Peartree Hill Solar Farm

Environmental Statement Addendum Revision 2

Application Document Ref: EN010157/APP/8.2

August 2025

- | No. | Viewpoint   | A3 |

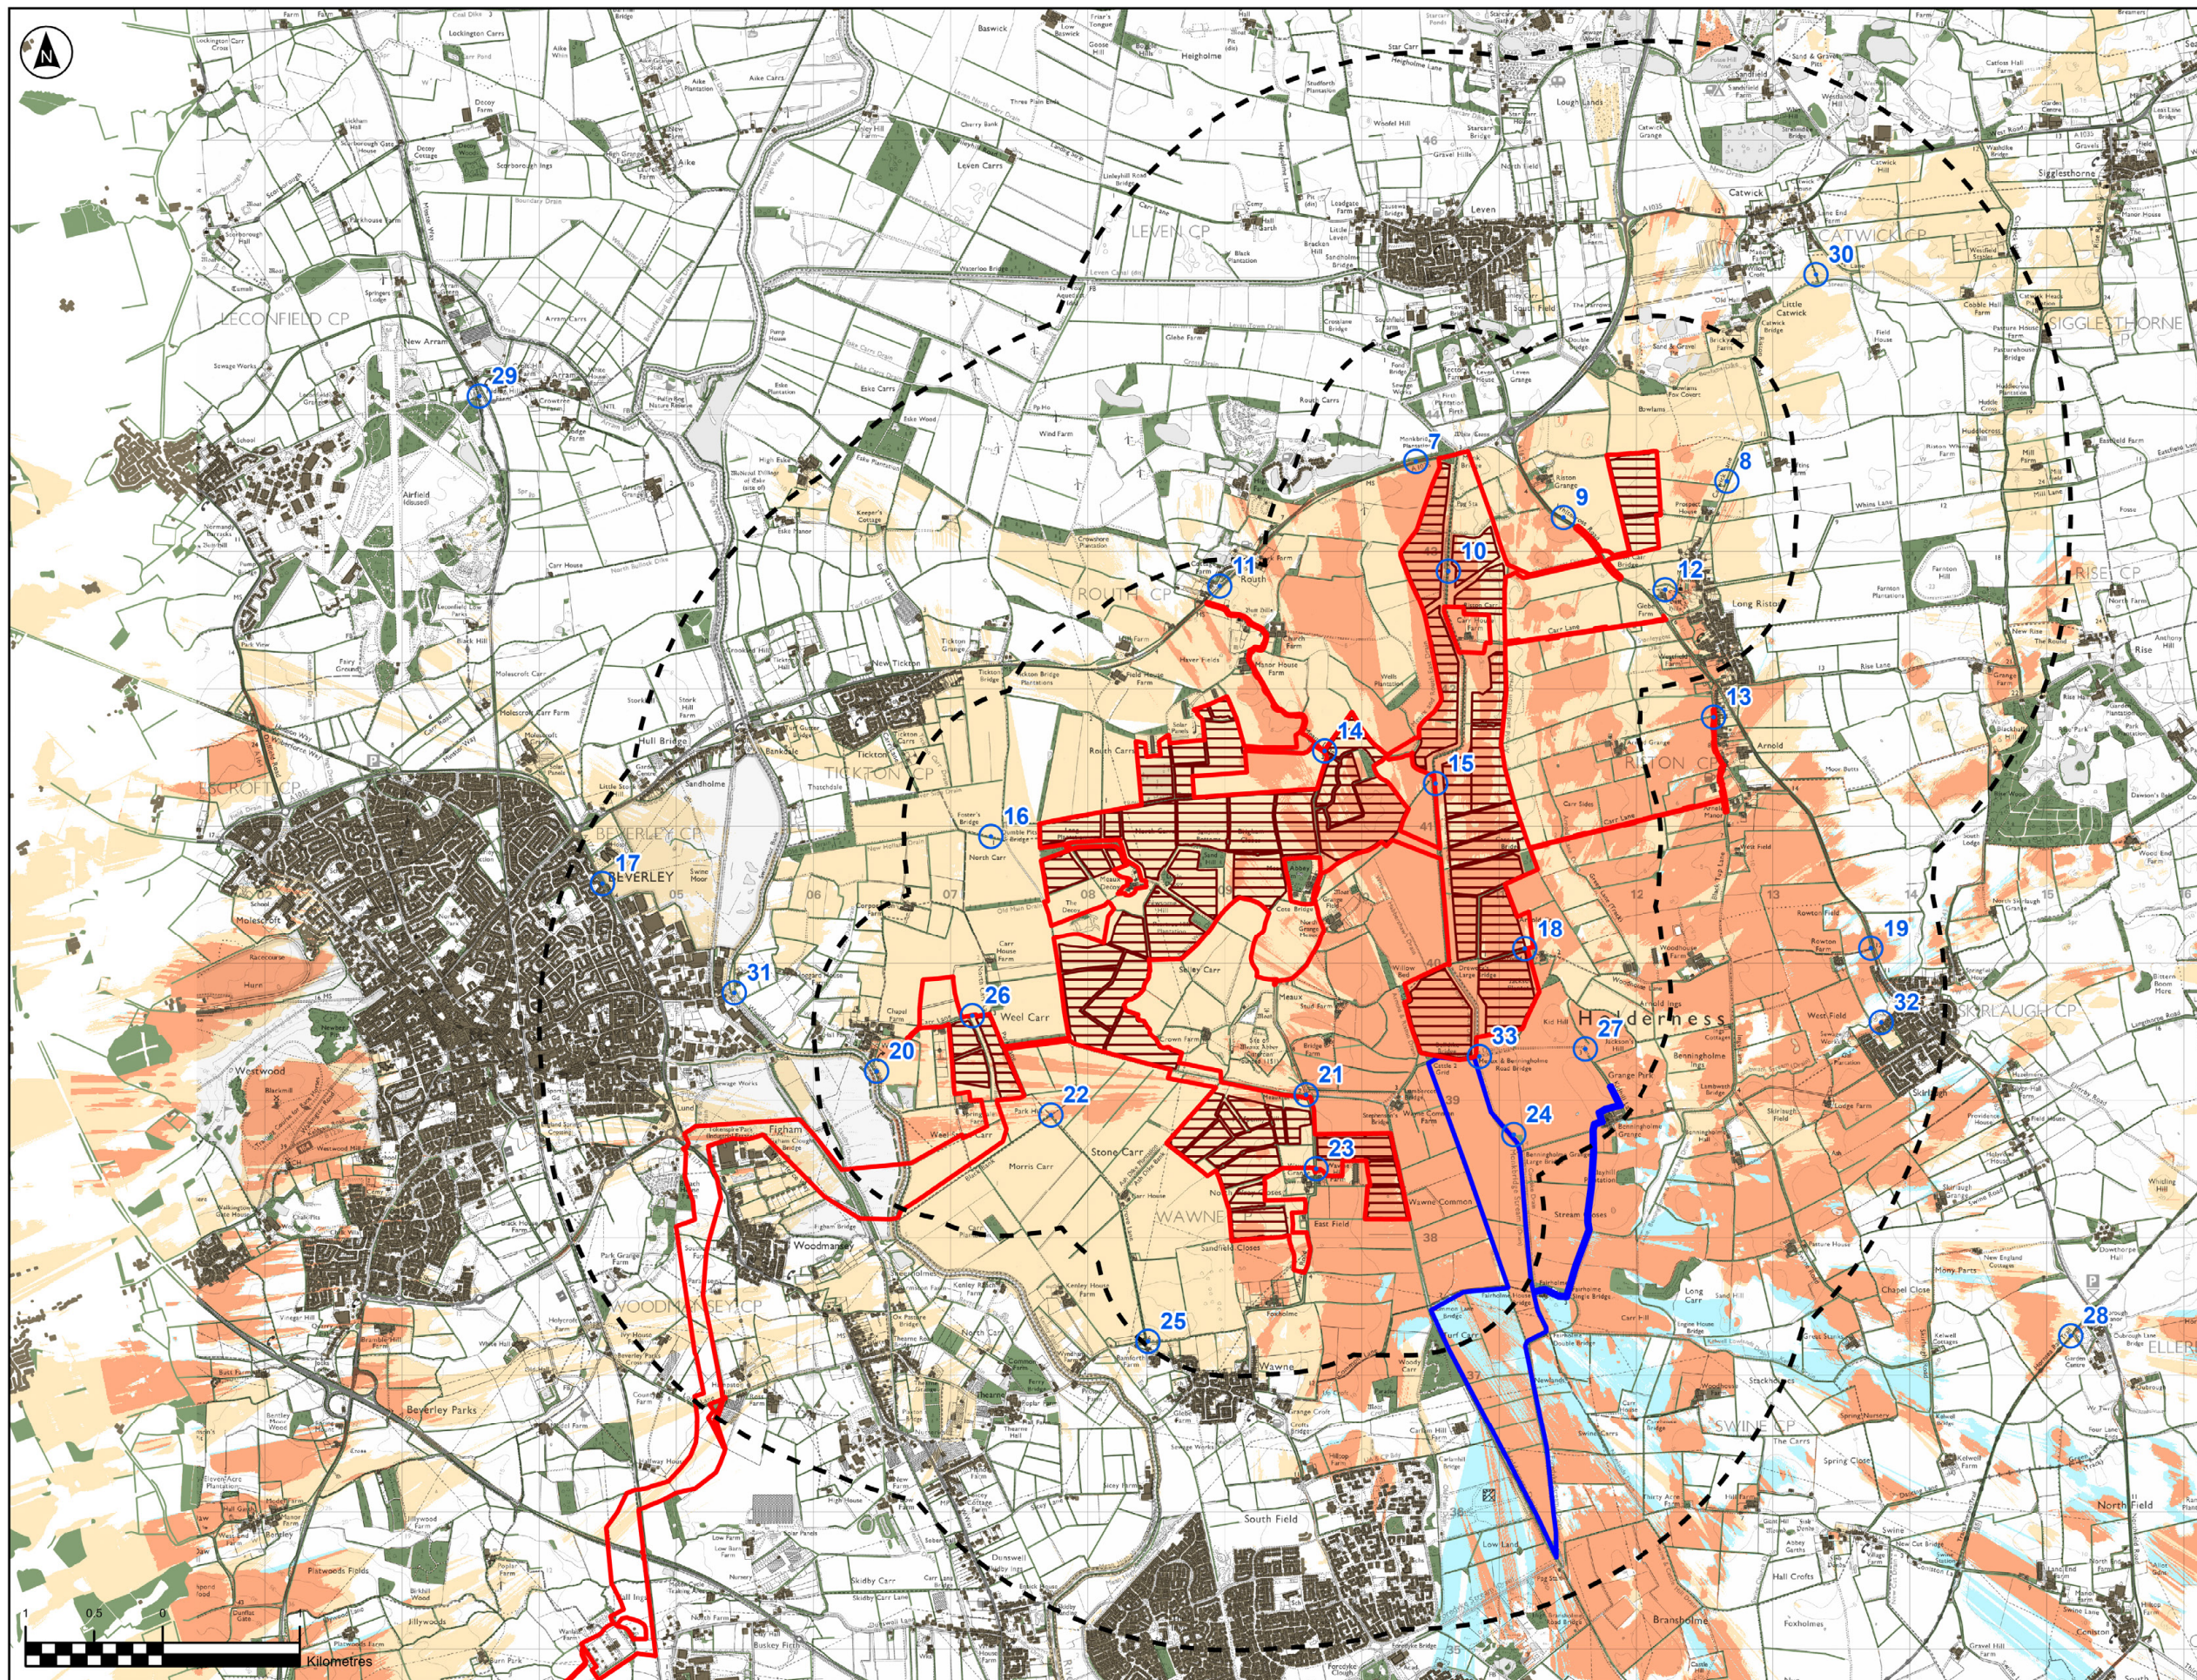
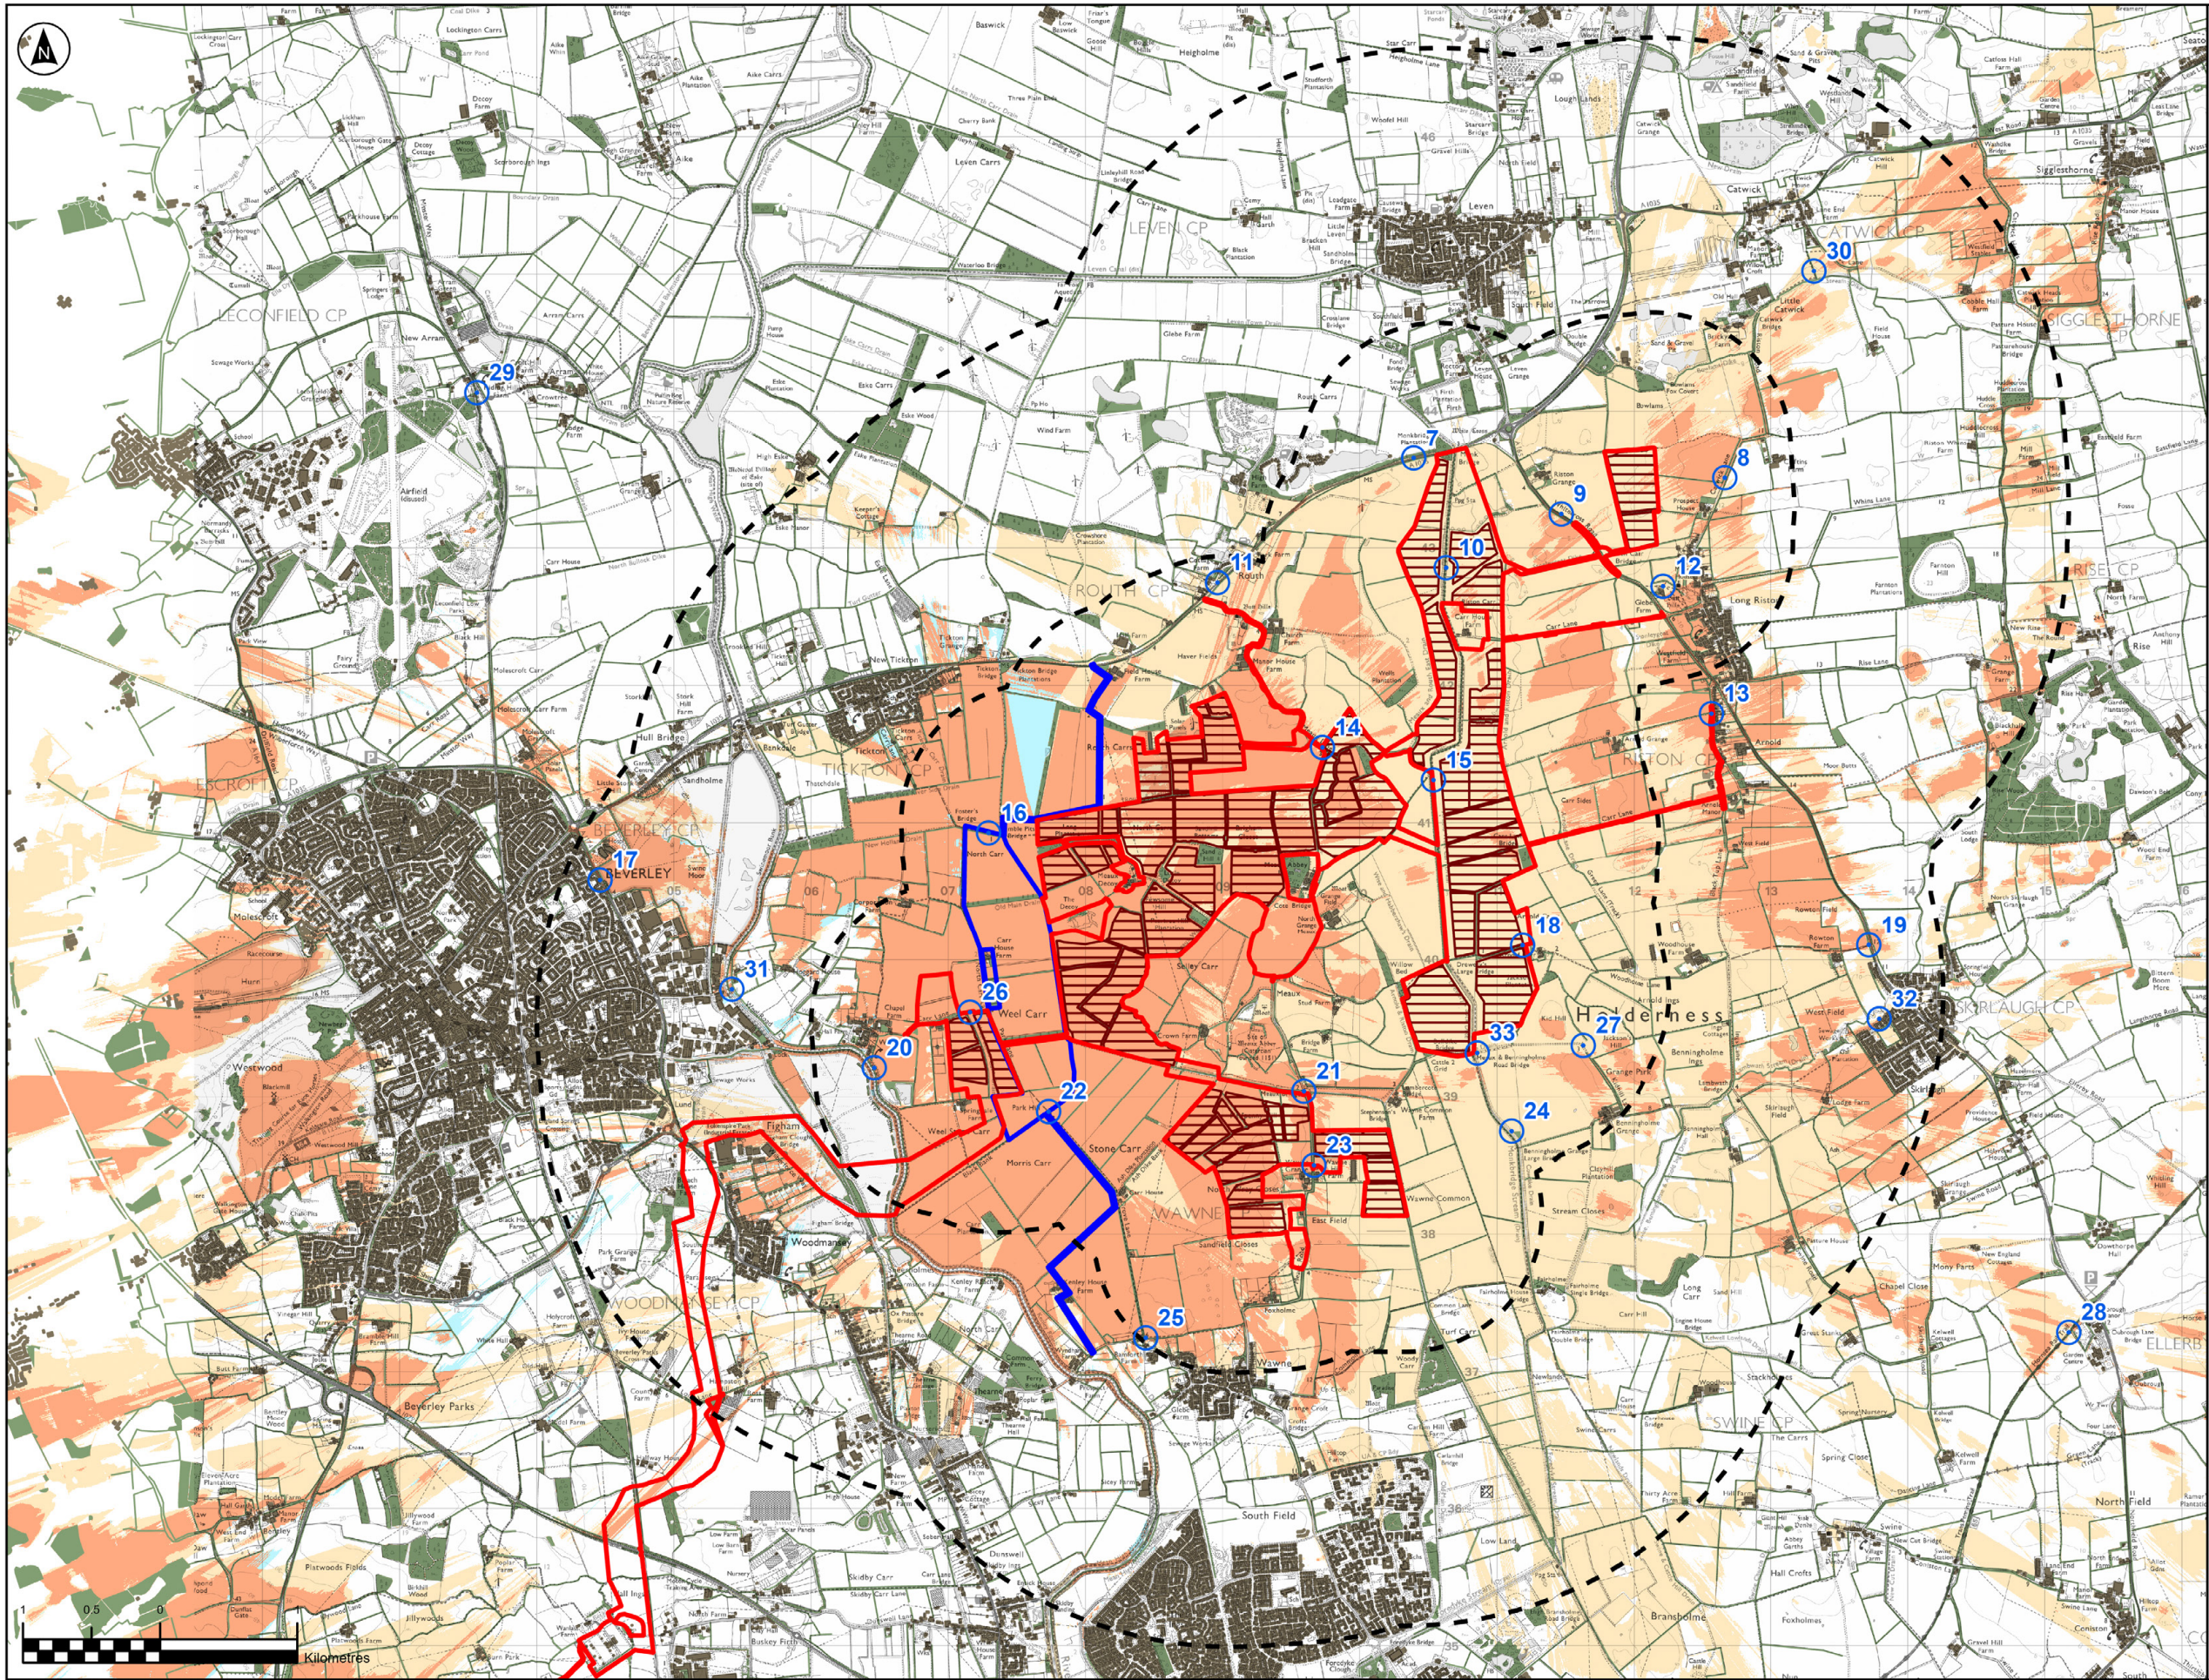
Document reference	Reason for amendment	ES Amendment August 2025
ES Volume 4, Appendix 15.2: Cumulative Landscape and Visual Impact Assessment [APP-144]	<p>Response to the ExA's First Written Questions [PD-008] (1.10.28 c)).</p> <p>Updates required to include a missing receptor ('Tickton PRow located between Tickton and Weel') in summary paragraph 3.8.4.</p> <p>When correcting the paragraph, the Applicant noted that three receptors had been included in paragraph 3.8.4 incorrectly. Updates required to move these receptors to a new paragraph.</p>	<p>A new paragraph 3.8.3 is added, which states:</p> <p>"For some receptors it is acknowledged that the addition of the five schemes considered in this cumulative assessment, in addition to the Proposed Development, would increase the geographic area where effects would be felt. However, they would not create significant cumulative effects beyond those already identified as being created by the Proposed Development alone. Those receptors to which this applies are:</p> <ul style="list-style-type: none"> • Meaux Lane/Meaux Road; <ul style="list-style-type: none"> ○ Cumulative effects identified, but overall not greater than those identified for the Proposed Development alone. • PRow Riston footpath no.2; <ul style="list-style-type: none"> ○ Cumulative effects identified, but overall not greater than those identified for the Proposed Development alone. • PRow Riston footpath no.1;
